Your Ref: OWPC19394
Our Ref: R/121/18/PDH 04-06-2018
Please ask for:
Zac Denton

Town and Country Planning Act 1990 (As amended)
Town and Country Planning (General Permitted development) Order 2015 Schedule 2 Part 1
Class A

Notification under extended permitted development rights for a proposed single storey flat roofed extension (to replace former conservatory) extending 5m from the original rear wall of the dwelling house, 3.6m high with an eaves height of 3m
4 Homefield Close Rustington

4 Hatched Close, Ruggington Proposed Extension AHC/01

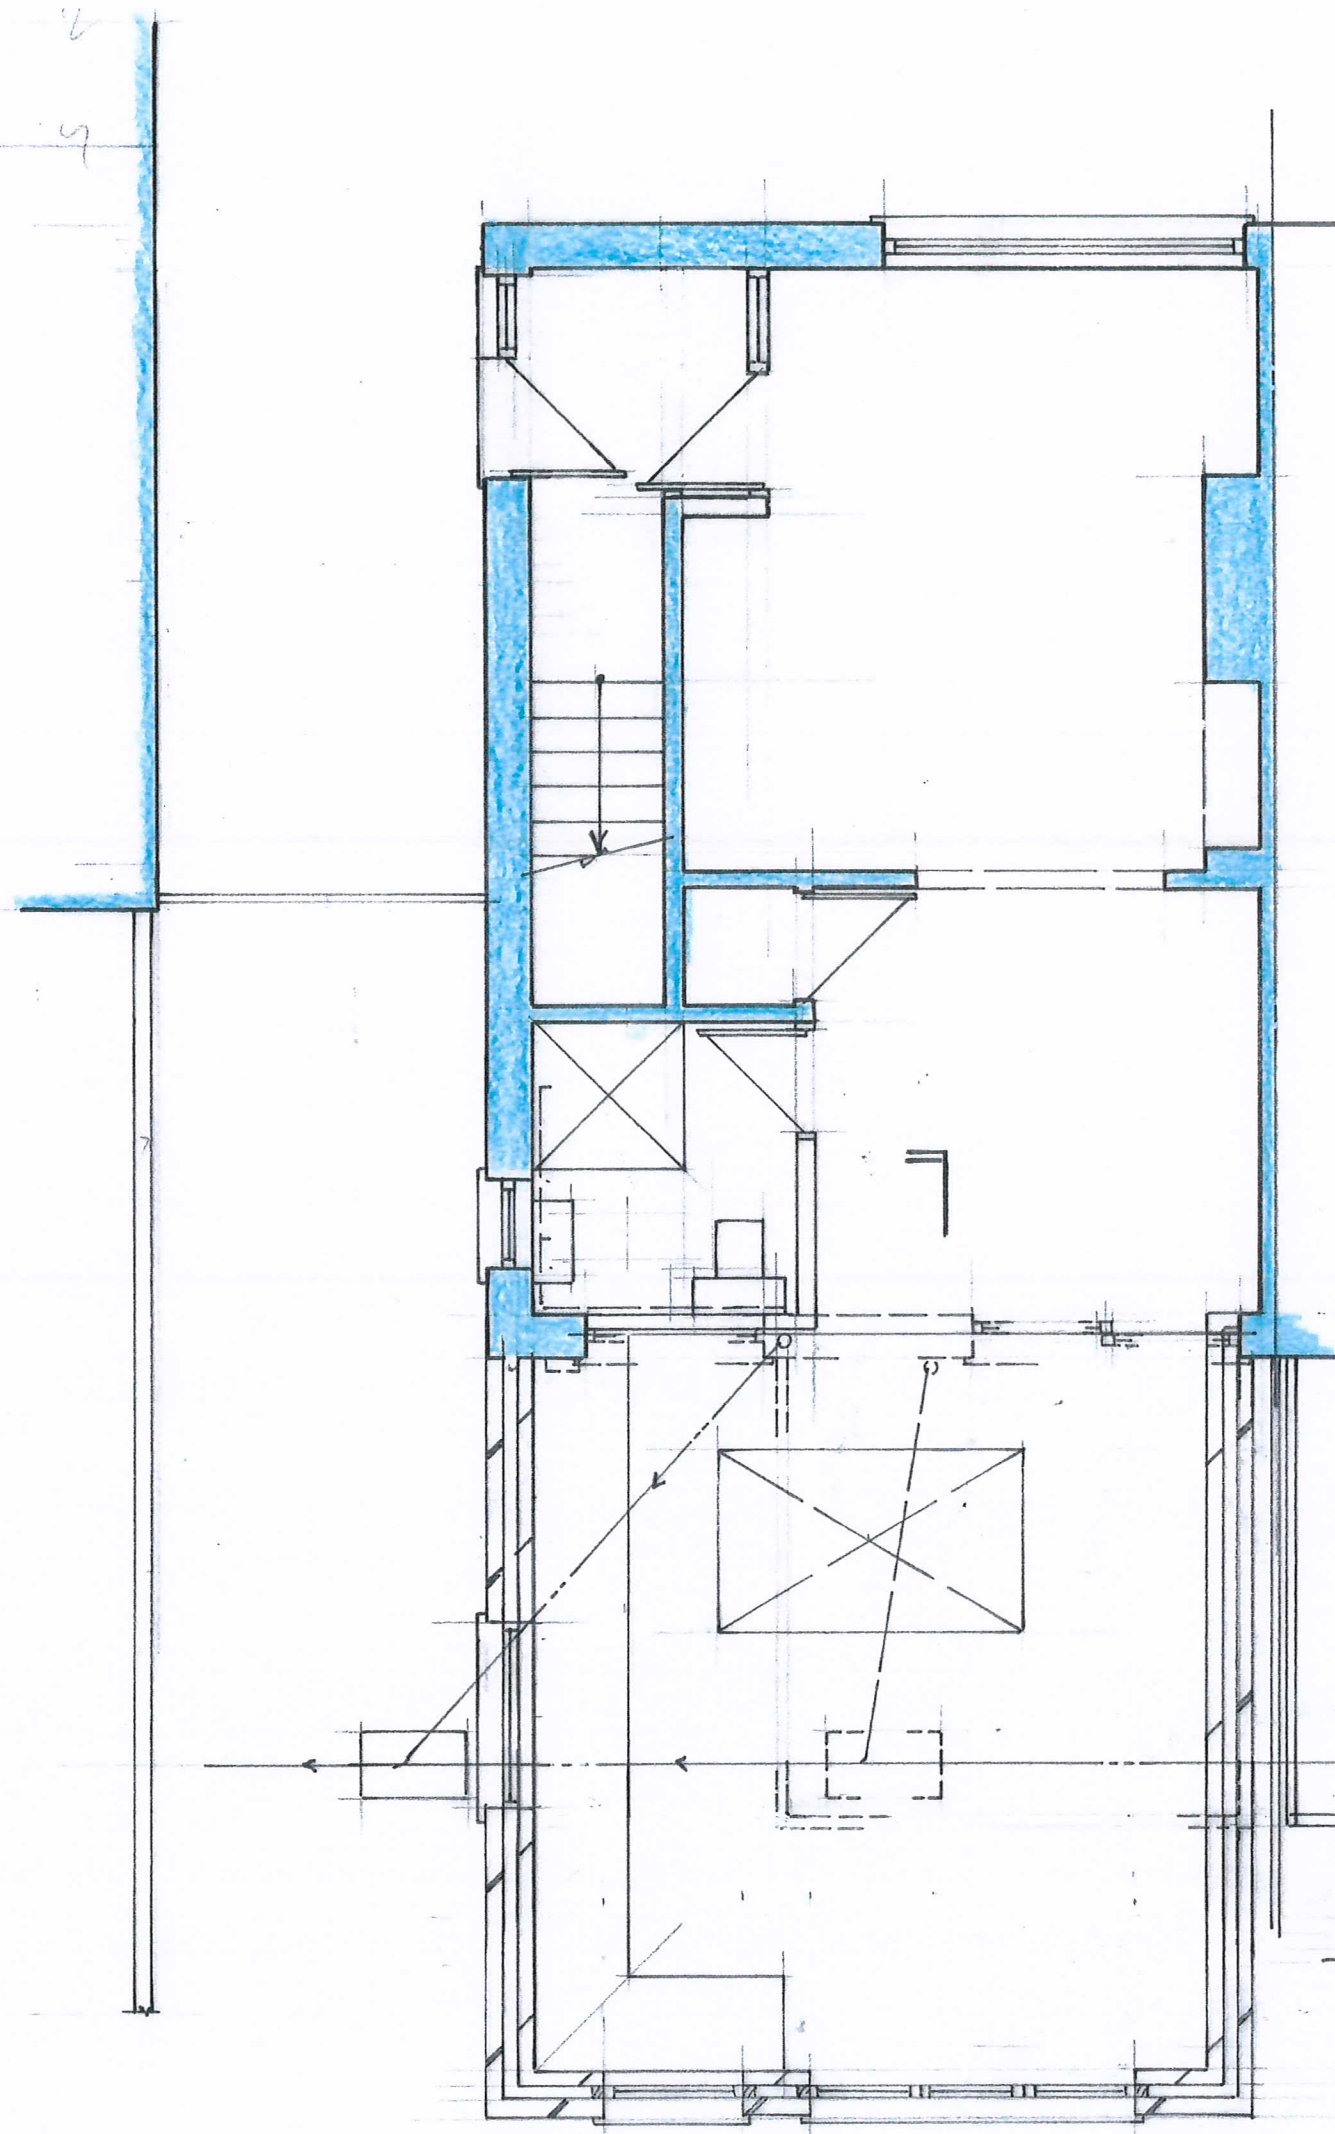
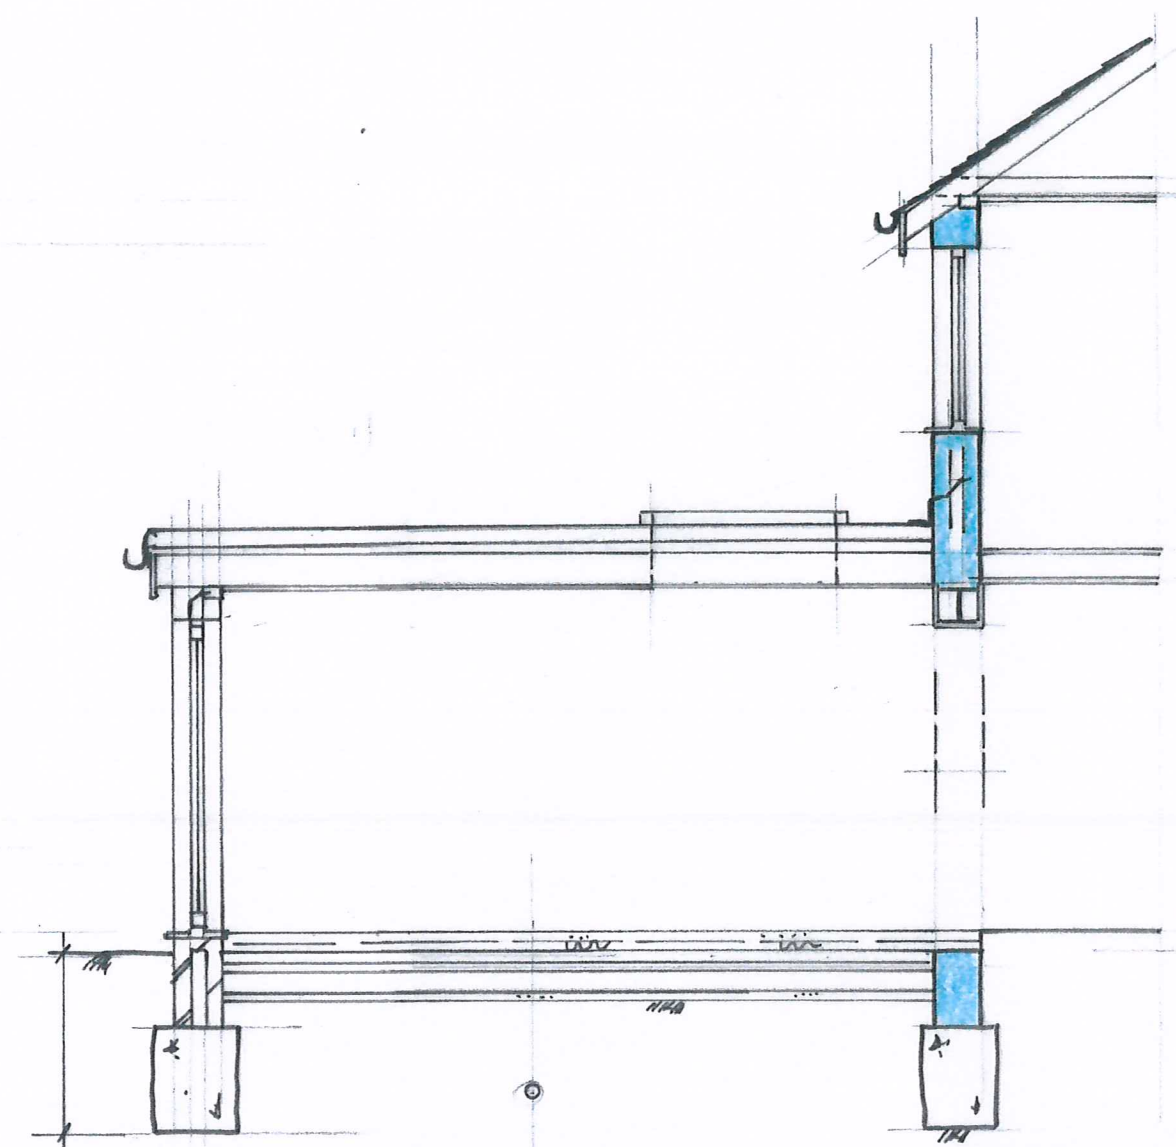
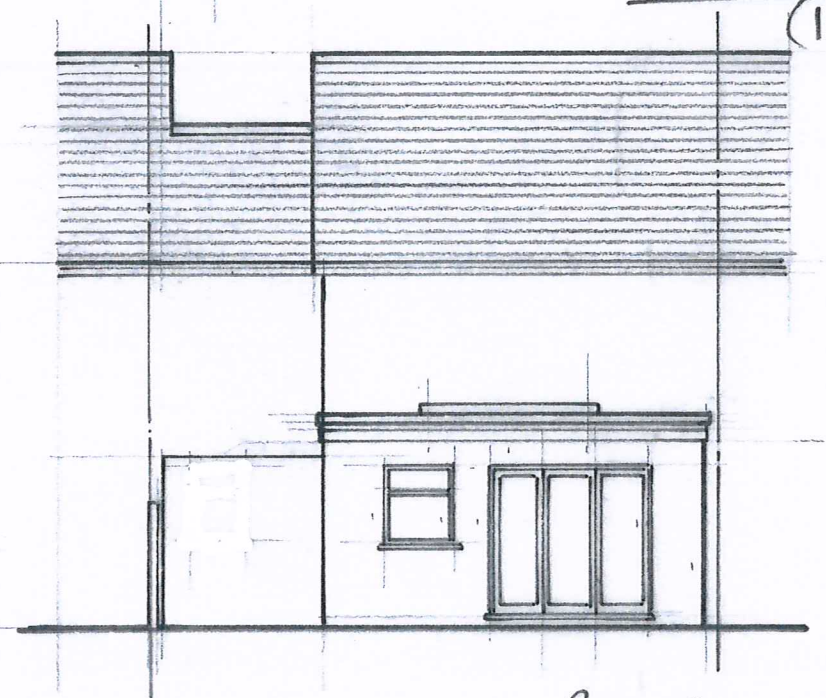
Firstly let Me state that I am in "objection" (at this present time ONLY) given a desire to hopefully glean some additional information from Yourself; as the drawings provided only indicate length and width of the rear extension at 5M (L) X 5M (W).

My main concern given the locality to our rear boundary (running parallel to the proposed extension, S to N); is both the Eaves AND External Height requests (measured externally from ground level), at 3.0M (Eaves) and 3.6M (Overall); respectively.

This to Me appears somewhat of an excessive height for modern day flat roofed extensions; with the more common being (as I have been advised by builders) at a lower eaves/overall height. Such a height at 3.0M runs a real risk of being detrimental to our view, reducing natural light (by casting a rather looming shadow over the entirety of our rear garden); which I am sure would only be compounded even further, when the sun is setting in the West of an evening.

As I understand it the overall height (measured externally from ground level) would be just over 3.0M's, as it is flat roofed and I assume that the insulation is directly on top of the rafters?
